M5 Junction 10 Improvement Scheme Road Safety Audit Report TR010063 – APP 9.15

SAFETY AUDIT

M5 Junction 10 Improvement Scheme
Cheltenham

Stage 1

Drawing Number	Project	Originator	Volume
GCCM5J10 - ATK - HGN -	J3_JN - DR - CH - 000001		
Location	Type	Role	Number
Original Size: A1	Scale: 1:1000	Project Ref. No.: 5197035	Sheet: 12 of 17
		Rev: C06

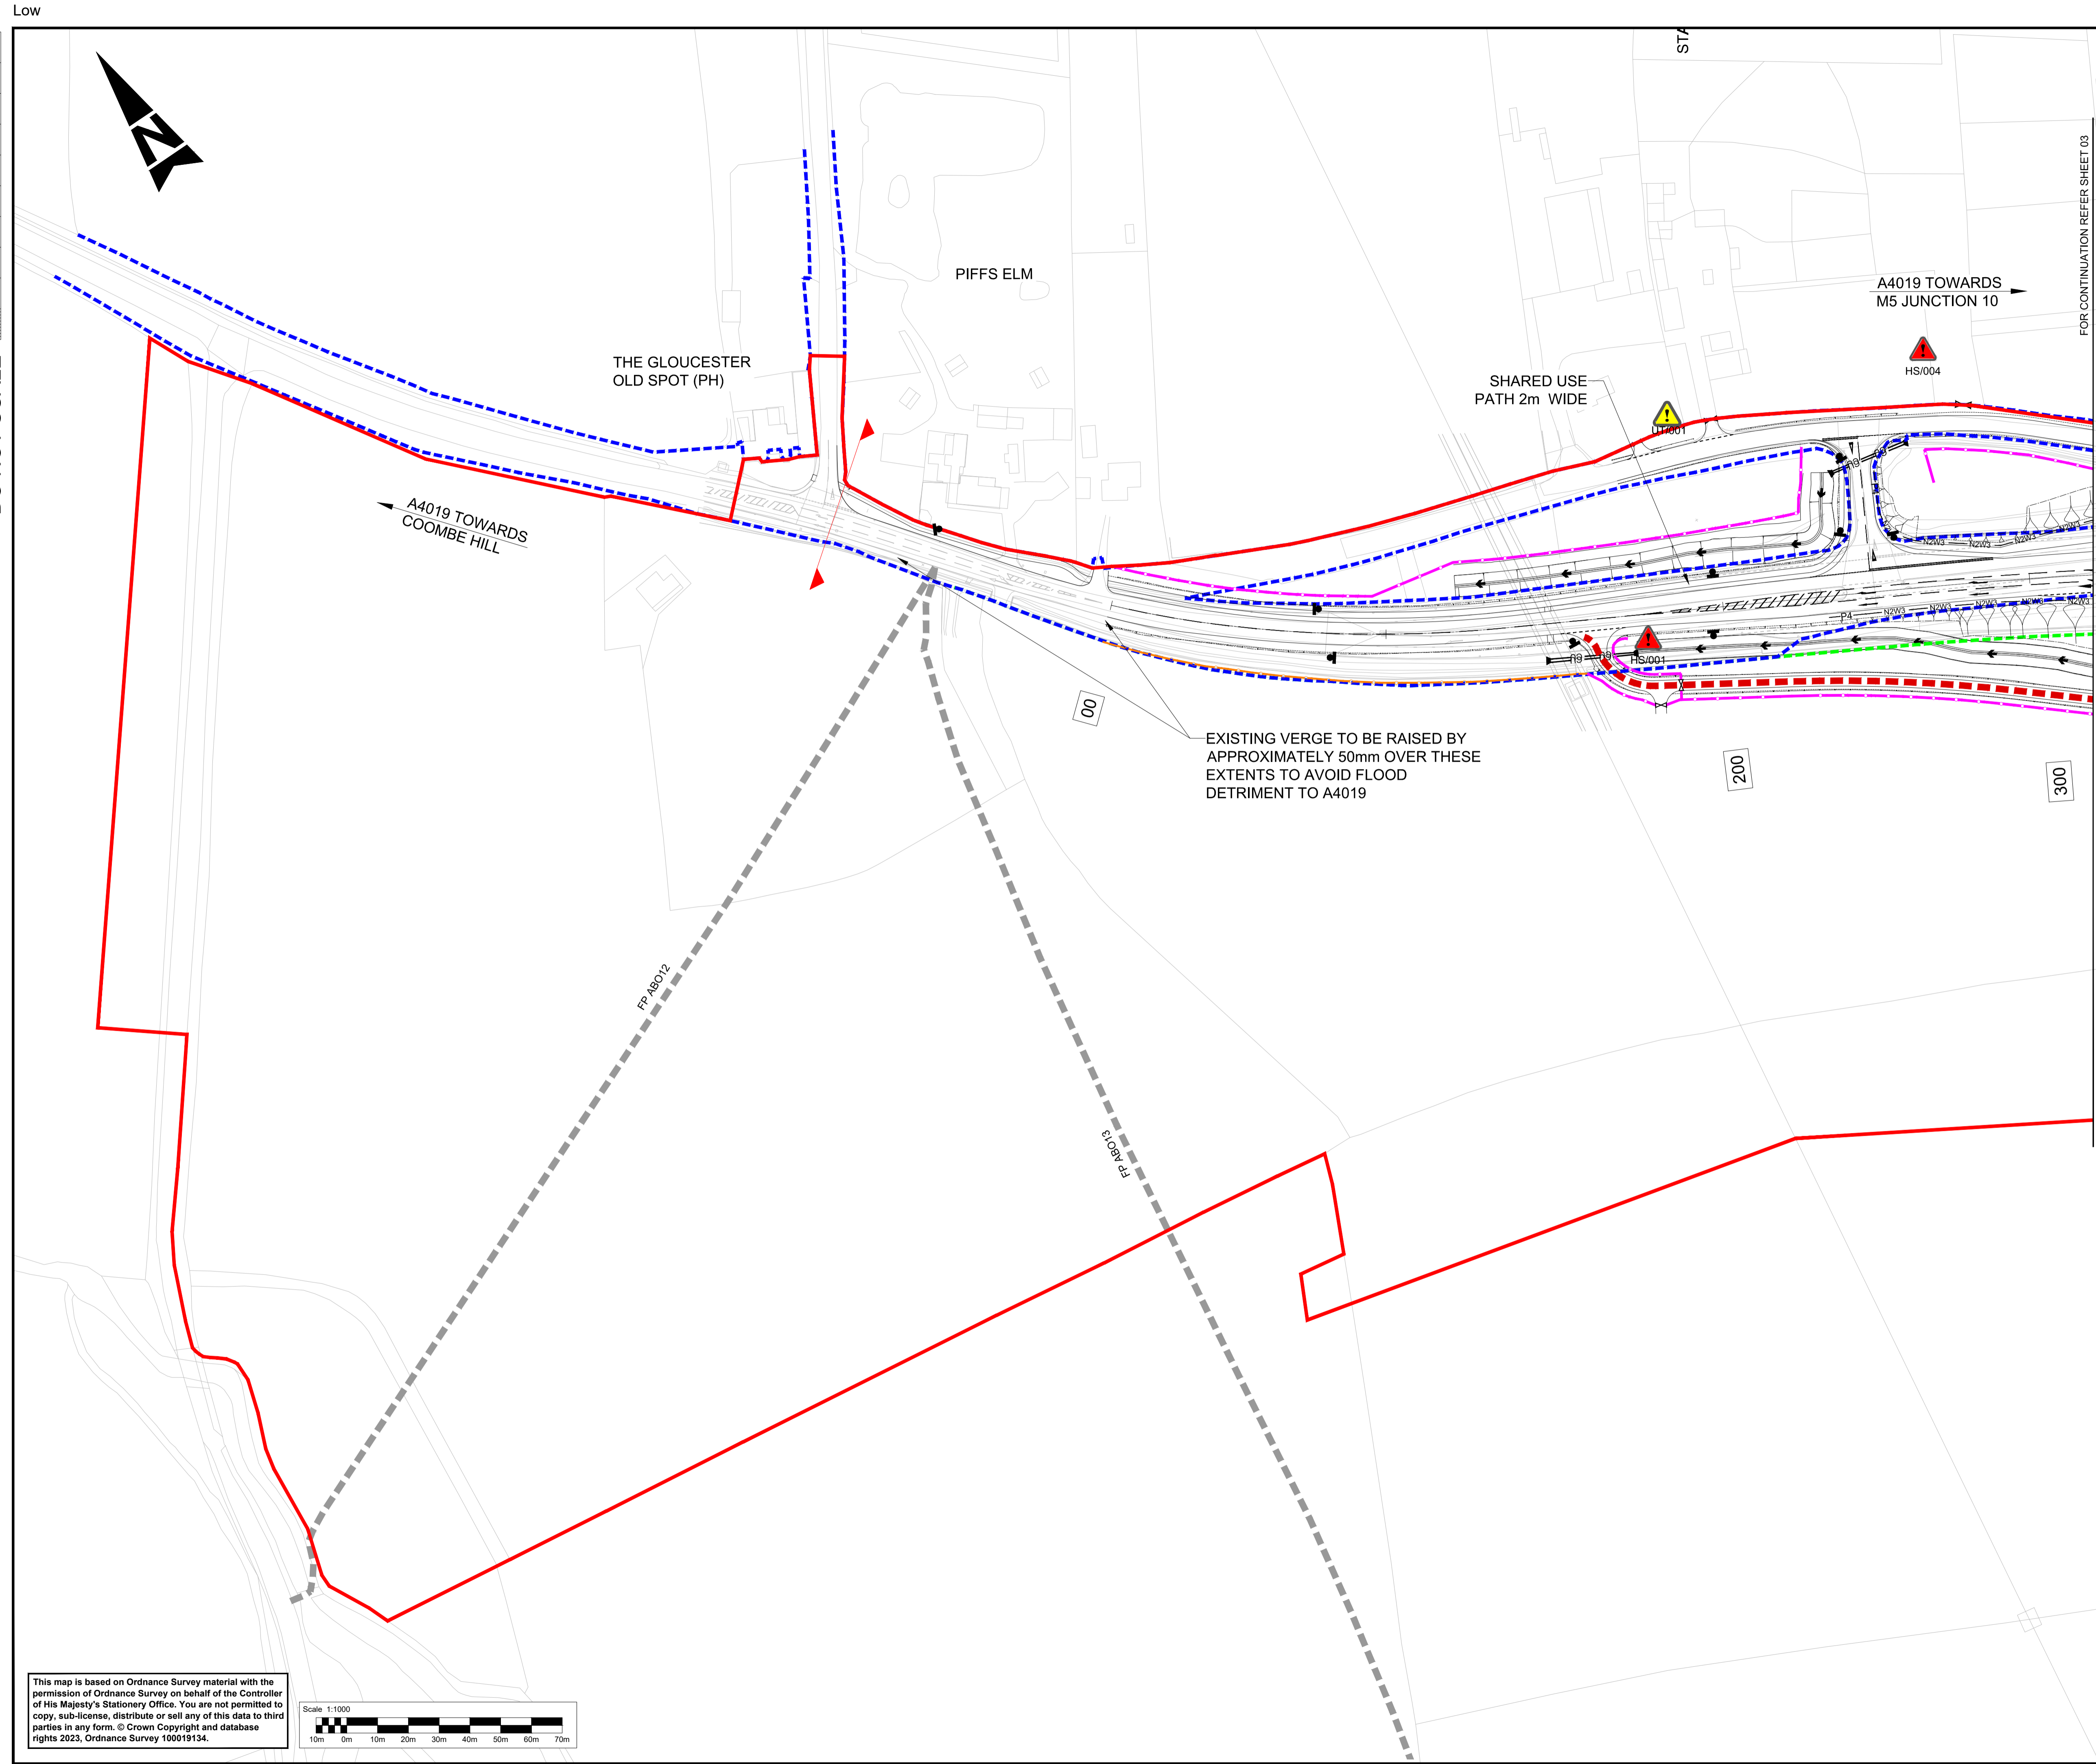
- A4019 Jct with the B4634 and the new junction to Developers site Access B on plan GCCM5J10-ATK-HGN-J4_JN-DR-CH-000001.
- A4019 Jct with Developers site access A shown on plan GCCM5J10-ATK-HGN-L1_ML-DR-CH-000002
- A4019 Jct with The Green and Moat Lane, shown on plan GCCM5J10-ATK-HGN-L1_ML-DR-CH-000001
- A4019 Jct with West Cheltenham Link Road and new Road to the North, shown on plan GCCM5J10-ATK-HGN-J2_JN-DR-CH-000001
- B4634 Jct with West Cheltenham Link Road, shown on plan GCCM5J10-ATK-HGN-J3_JN-DR-CH-000001

The audit team raised a concern regarding the width of the pedestrian/cycle refuges located at the junctions listed above. The width of the refuges was not shown on the plans and a concern was raised regarding the width available to house a cyclist waiting to complete their crossing. If the pedestrian refuges located at the junctions above are not wide enough to safely house a cyclist, they could be clipped by vehicles travelling through the junction possible resulting in a slight injury accident.

The audit team recommend that the width of all pedestrian refuges located at junctions that have cycle facilities either side should be wide enough to safely house a cyclist waiting to complete the crossing.
